DECISION DELEGATED TO HEAD OF PLANNING

Application No: H08-1031-25 **Applicant:** R K Wilson Builders Ltd.

Proposal: Erection of 6 single storey dwellings and garages, formation of parking and bin collection point and reinstatement of existing access - approved under H08-0282-24. Amendments to foundation design to that required under Condition 3 of approval H08-0282-24

Location: Riseholme Farm Windmill Lane Gosberton Risegate

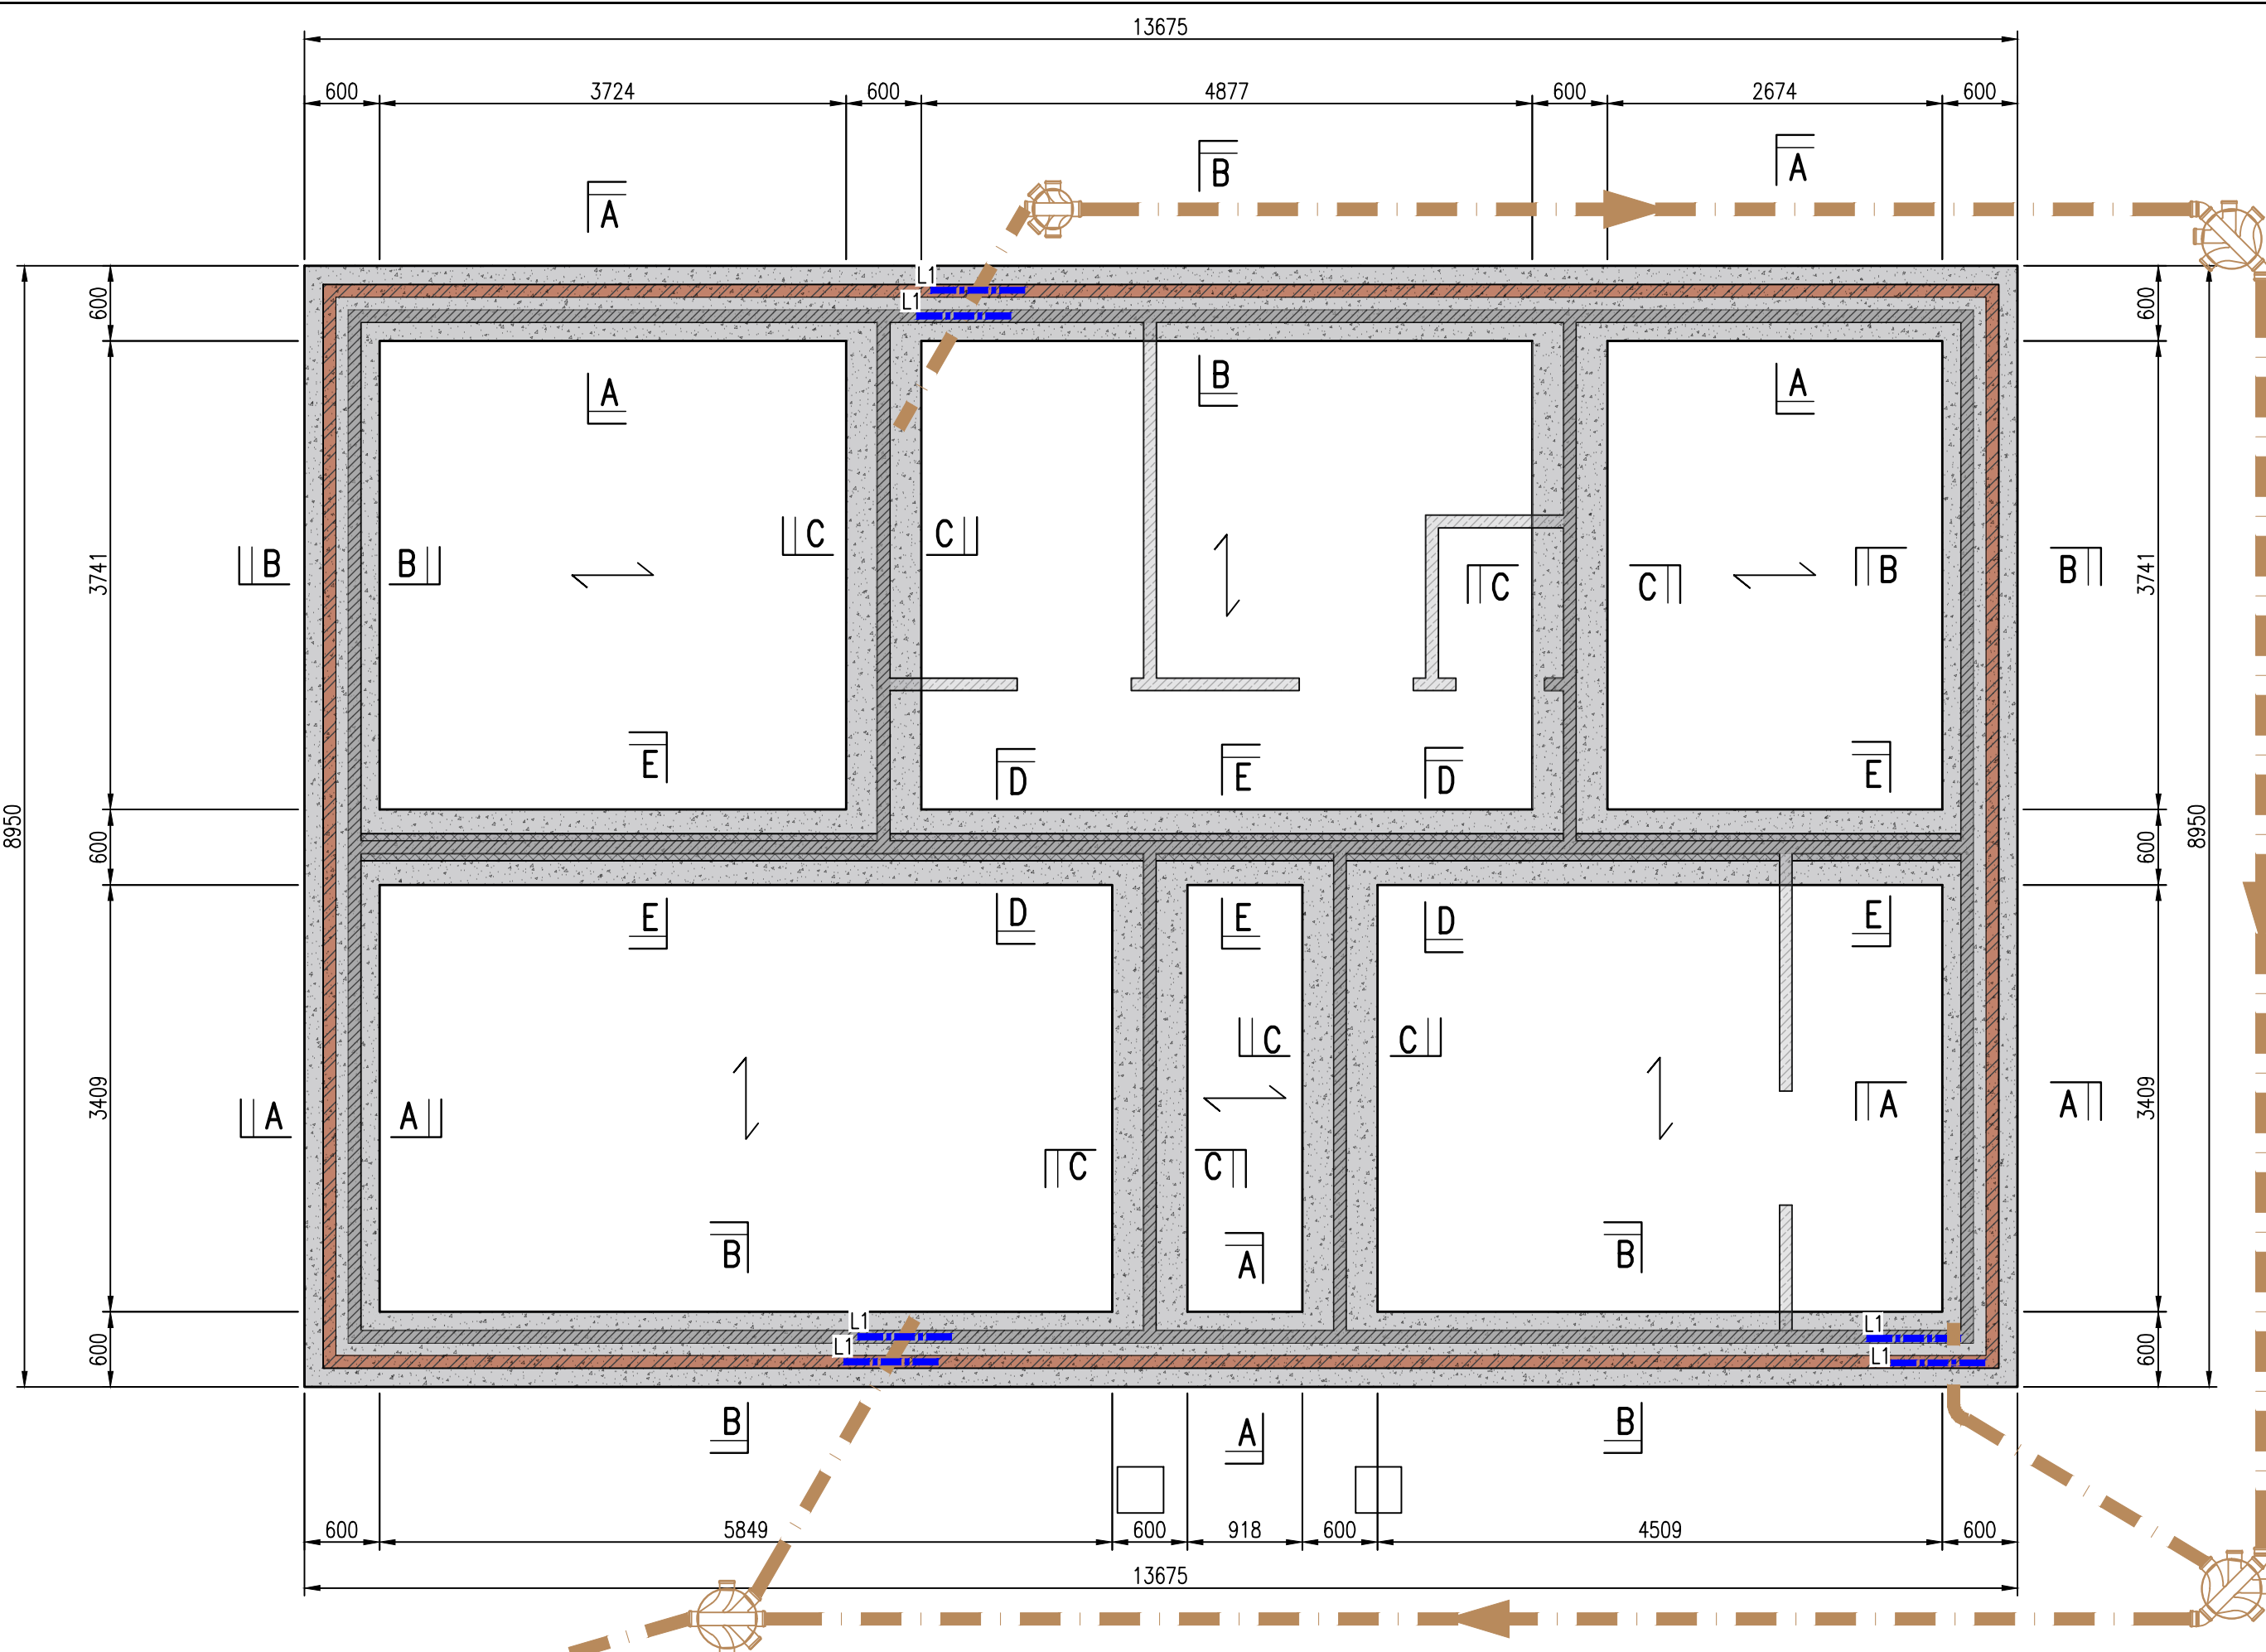
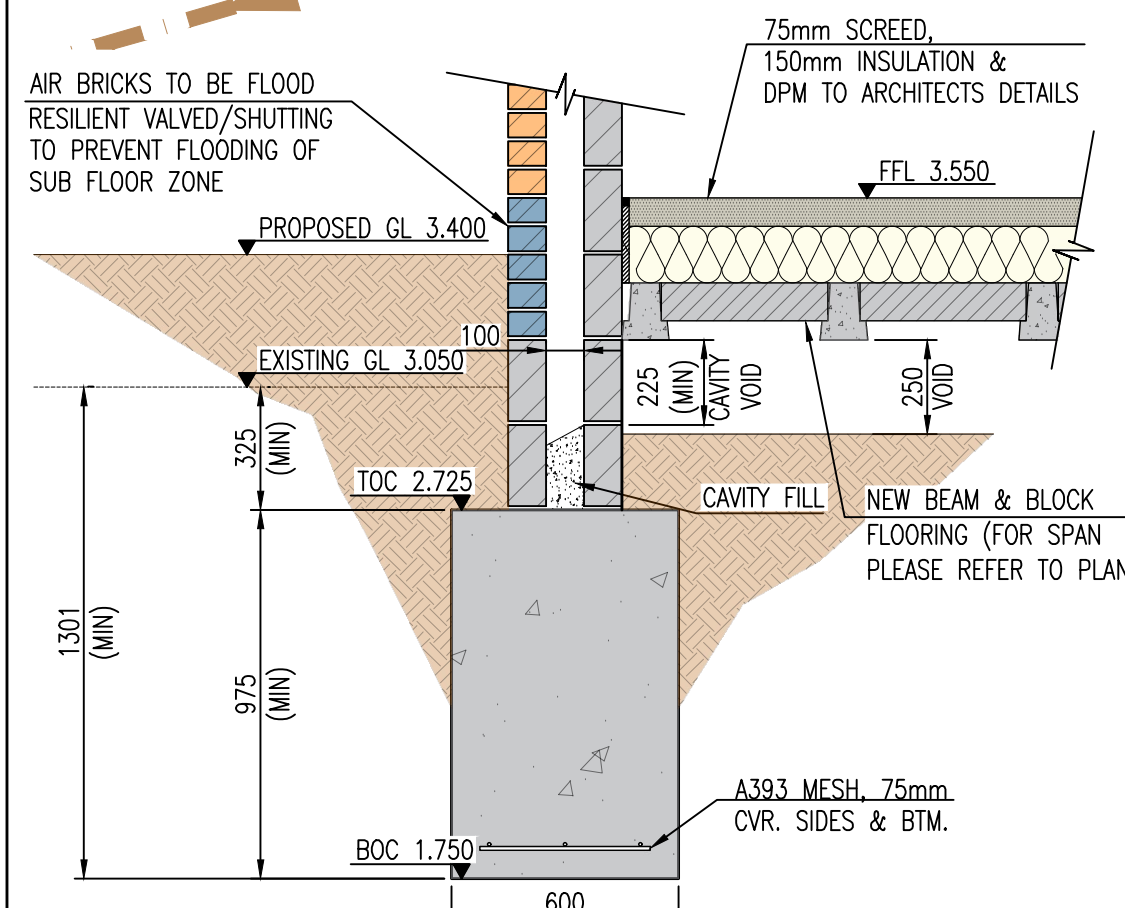
The applicant has provided plans showing a proposed strip foundation for all 6 plots.

Whilst the applicant has provided a series of foundation plans and technical information regarding air bricks (flood resilient ones), the submission does not provide an update of the Flood Risk Assessment approved under H08-0282-24. Condition 3 was derived from the mitigation measures outlined in this report by RM Associates.

Point 8 of the SHDC guidance on non-material amendments states that "The amendments must not result in a fundamental change in the design of the building". Given the mitigation measures set out by the FRA in that "The ground floor to be constructed with a solid concrete floor with no voids

beneath and no low-level wall vents". The move to a strip foundation with voids beneath would represent a fundamental change in the design of the building.

Moreover, the new proposed foundation design is not supported by any flood related justification (an updated FRA). Given the application site is located within flood zone 3 in accordance with EA maps, it would be necessary to receive and consult upon such design changes that are imperative to the safety of future residents as regards flood risk.
